**SUBMISSION TO THE DEPARTMENT OF PLANNING AND INFRASTRUCTURE ON THE PROPOSED
NORTH WEST RAIL LINK (NWRL)**

Application Number: SSI-5100

Figure 6.11 Cheltenham Services Facility light vehicle access and egress

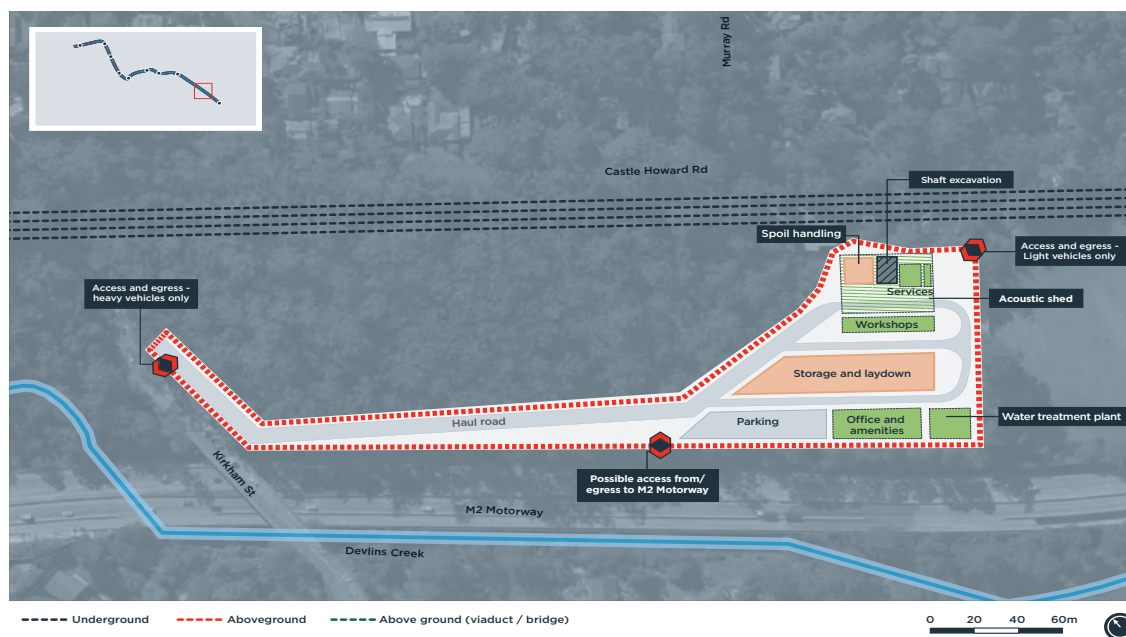
1. The option to construct a new two lane paved road through the Castle Howard Conservation Reserve to Kirkham Street (or Castle Howard Road) near the bridge over the M2 to allow trucks to remove spoil during construction and light vehicle access during operation of the facility will permanently destroy valuable Blackbutt Gully forest.

5. Should the roadway be built, the local streets (Kirkham Street, Castle Howard Road, Murray Farm Road and the bridge over the M2) are narrow, winding and congested and would not be suitable for trucks and, in the event of an emergency, large numbers of emergency vehicles.

6. There are no traffic lights at the corner of Kirkham Street and Beecroft Road. This is a dangerous intersection for traffic and pedestrians and would not be suitable for trucks and emergency vehicles.

I therefore ask that you adopt the alternative option of access to the site for construction and emergency vehicles be via new on and off ramps from the M2 motorway. The current widening and reinstatement of the breakdown lane should allow this access. It is the only practical way to move trucks in and out of the site. In the event of an emergency, many emergency vehicles would need quick access to the site from areas outside Beecroft and Cheltenham as it only has one fire engine.
